POST EPC MEMORANDUM

TO: CABQ Development Facilitation Team (DFT)
FROM: Catherine Heyne, Planner
DATE: 10/08/25
RE: SP-2025-00041 – Site Plan - EPC, Major Amendment
1700 Unser Blvd NW – Heritage Marketplace

SP-2025-00041 –Major Amendment, Site Plan

1 Proposed Changes:
1. Indicate Tract B as "NOT A PART" on Sheet 1 of 3 as it is being repealed from the Site Plan.
2. Indicate Tract A as "NOT A PART" on Sheet 3 of 3 as it is being repealed from the Site Plan.

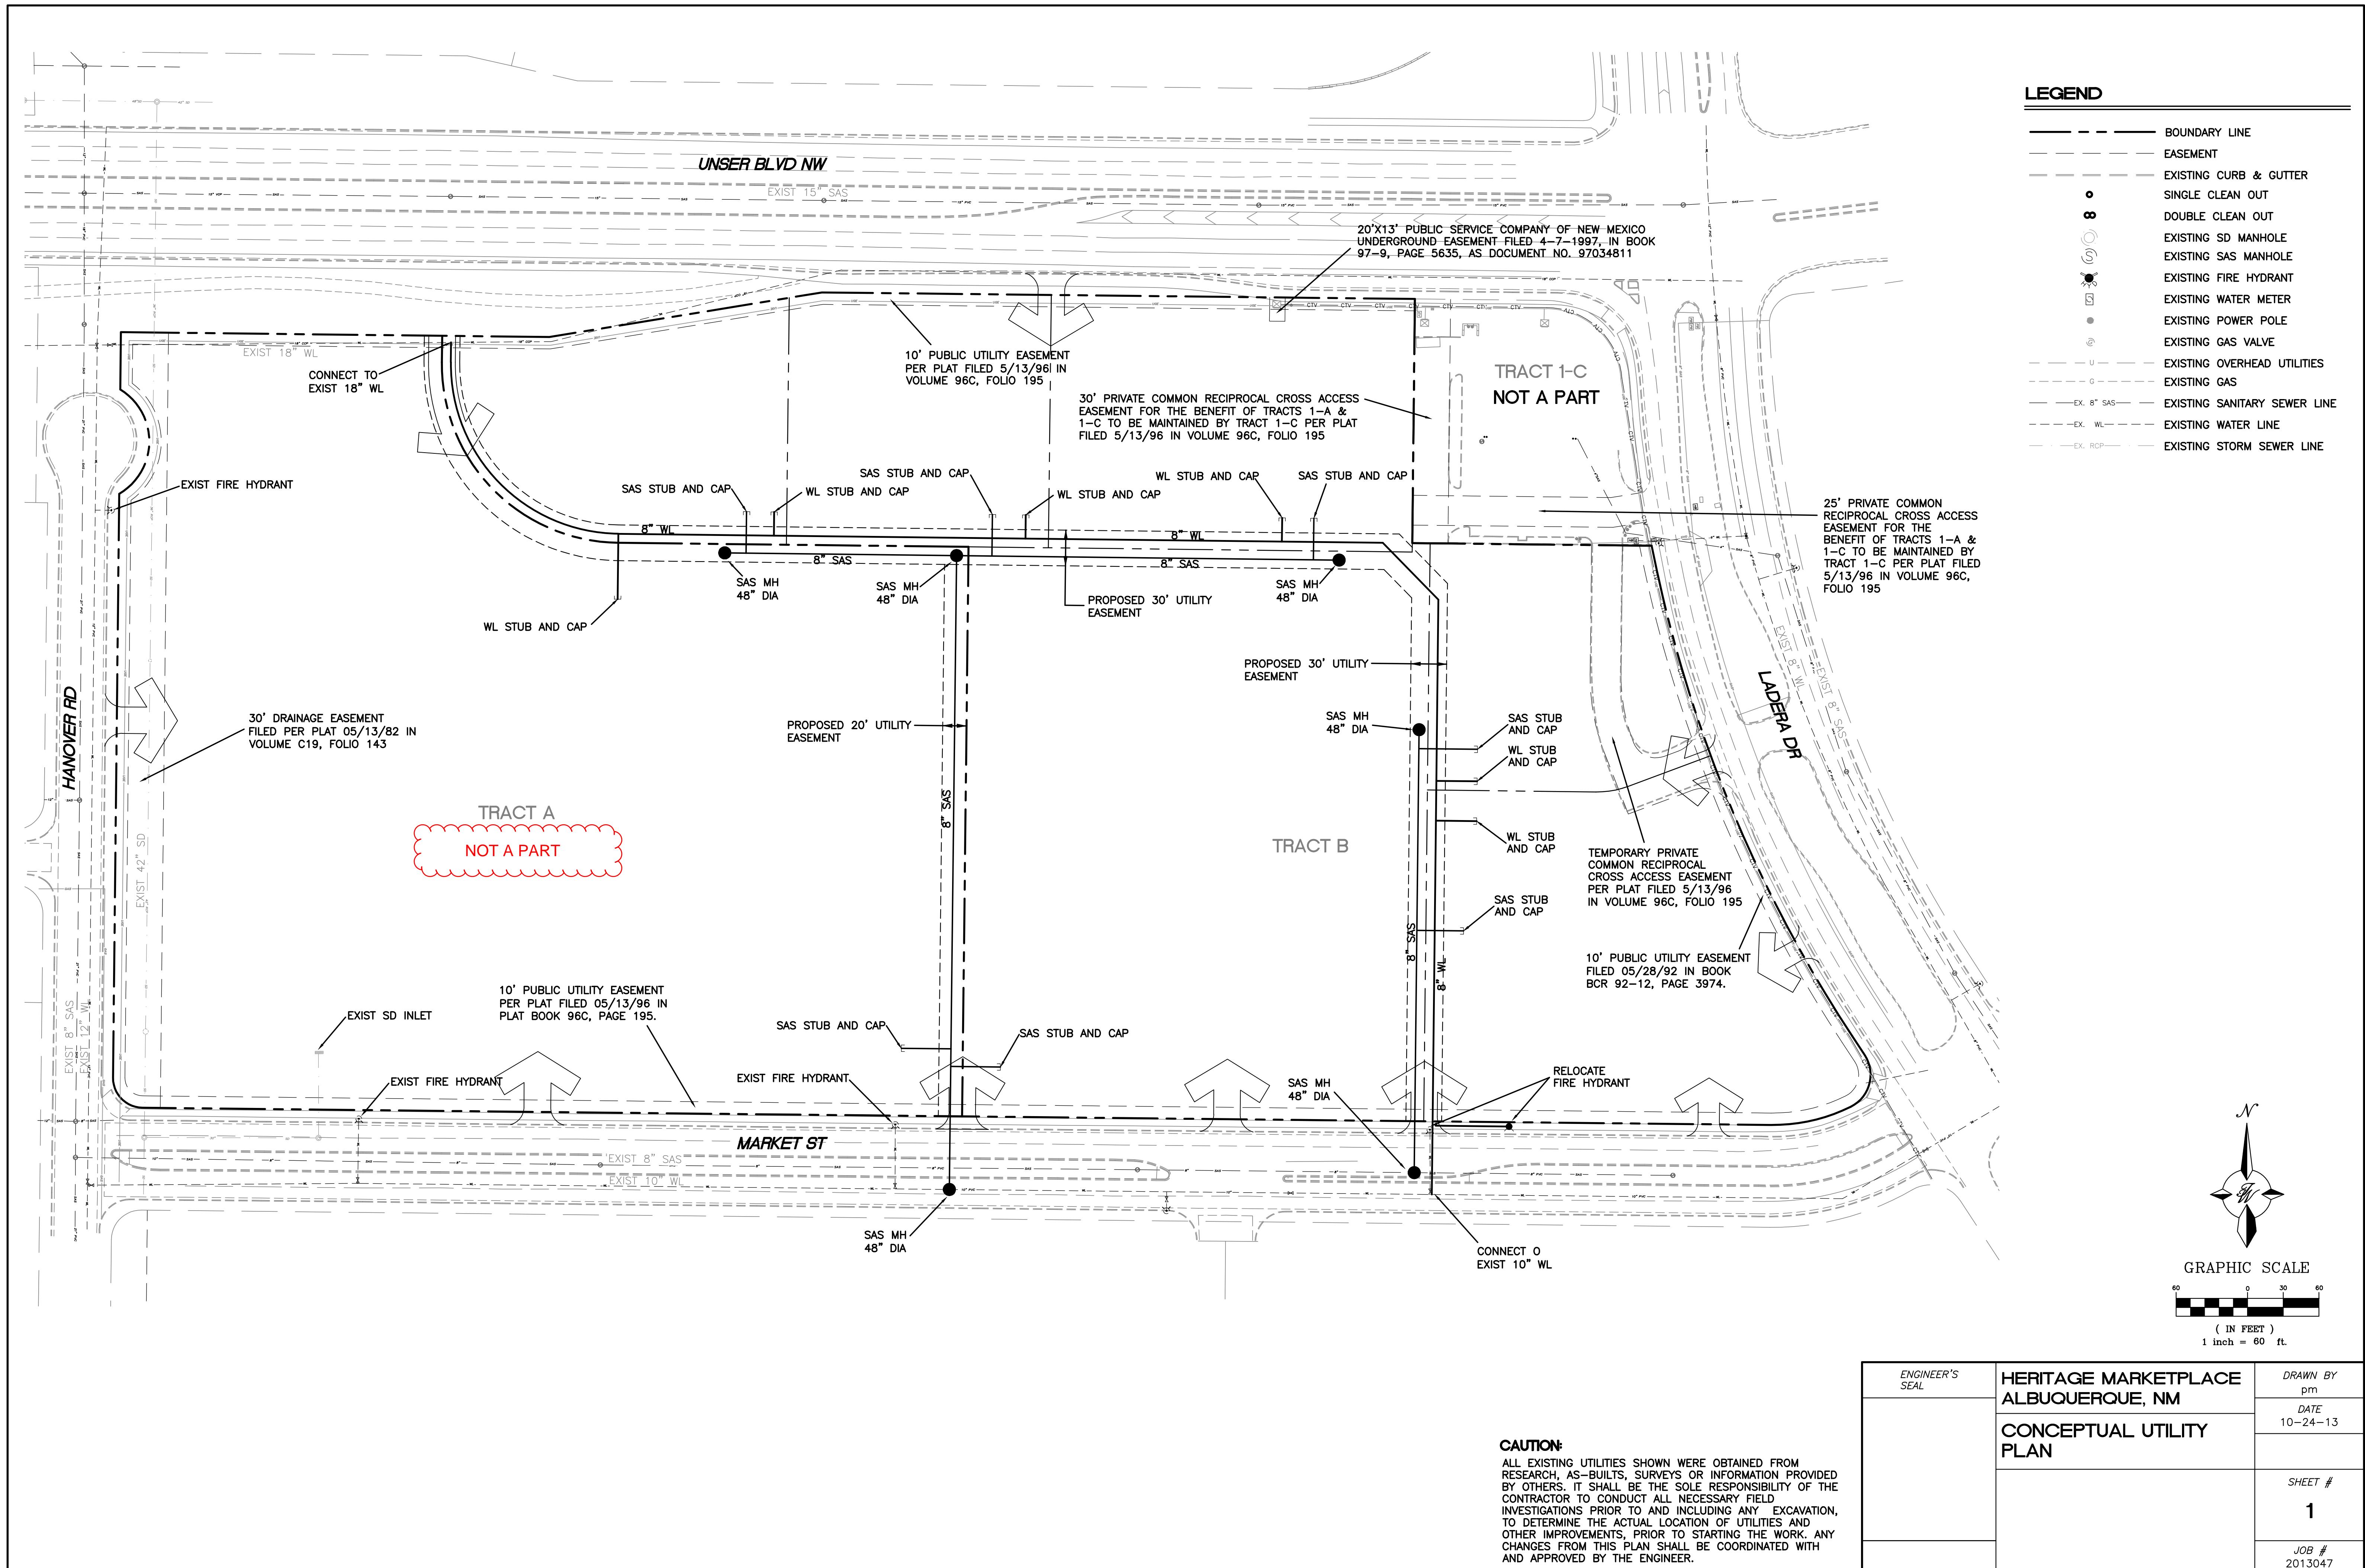
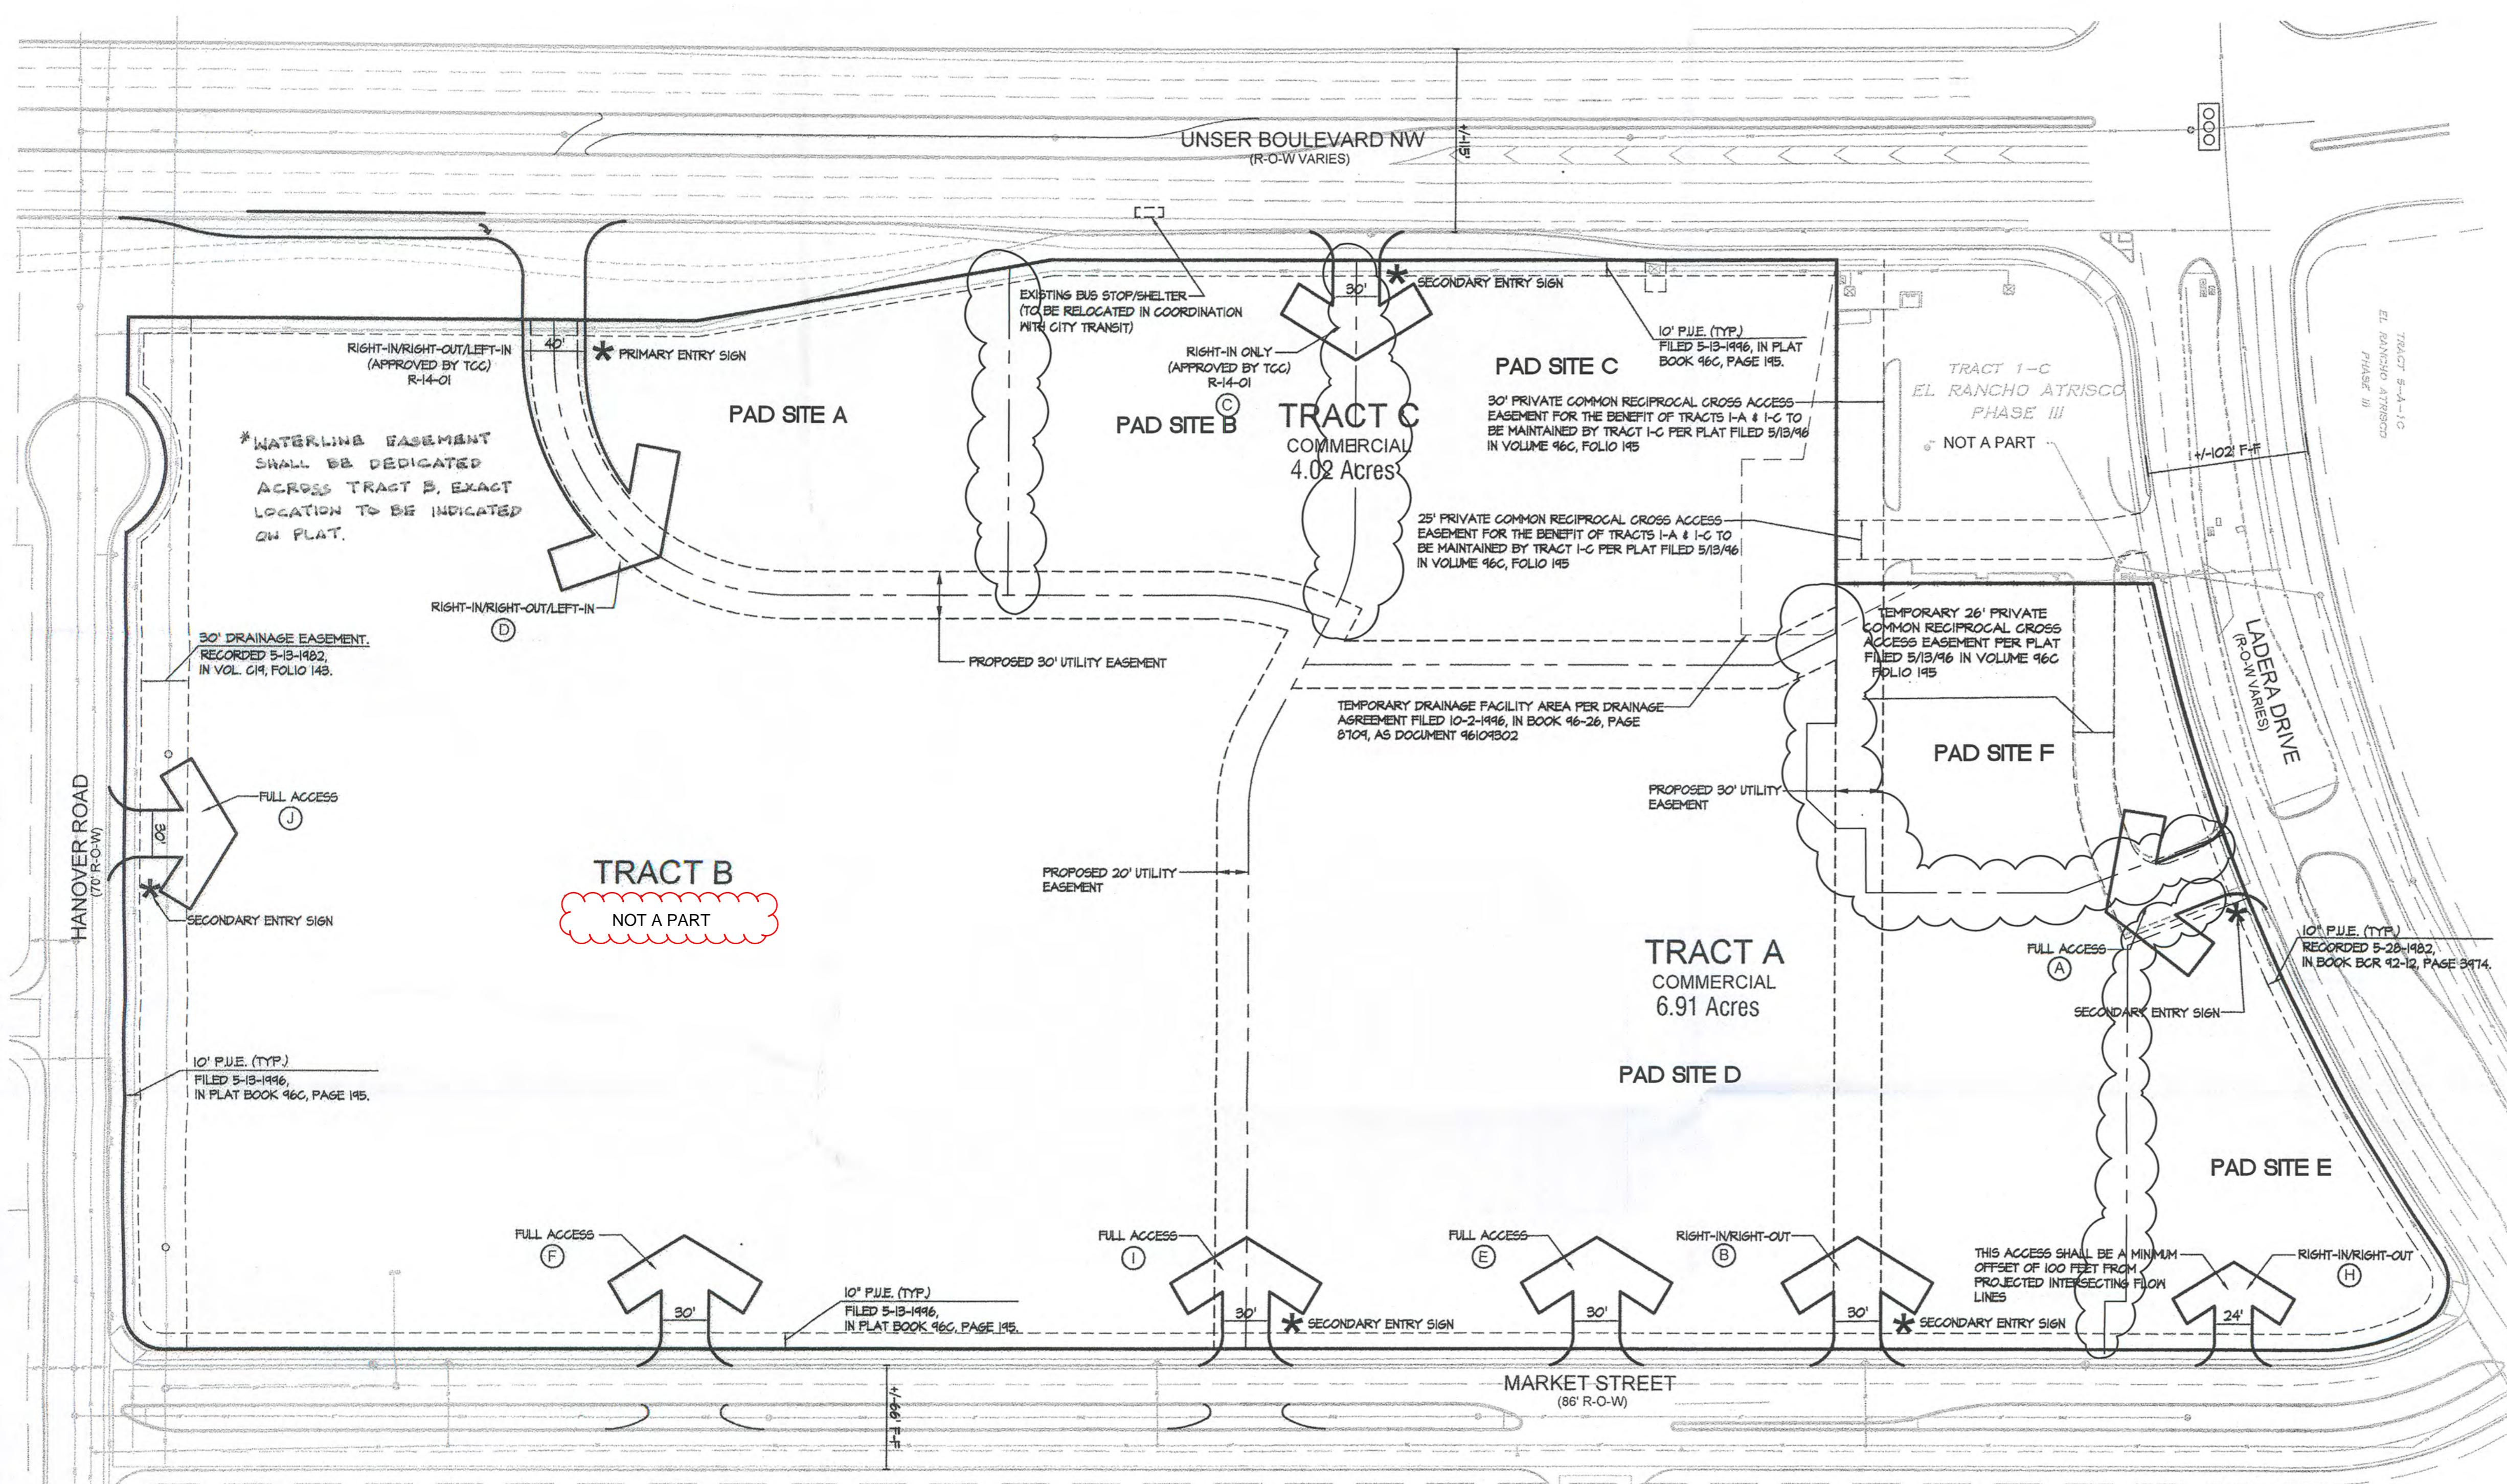
6. Condition 6: The text as part of “Proposed Changes: 2.”, as shown on Sheet 1, shall be removed as it is not applicable.

This Condition has been met; the referenced text has been removed.

7. Condition 7: The Site Plan for Subdivision boundary shall be updated to show its new extent without Tract B.

This Condition has been met; the site plan boundary has been updated with Tract B indicated as “Not a Part”.
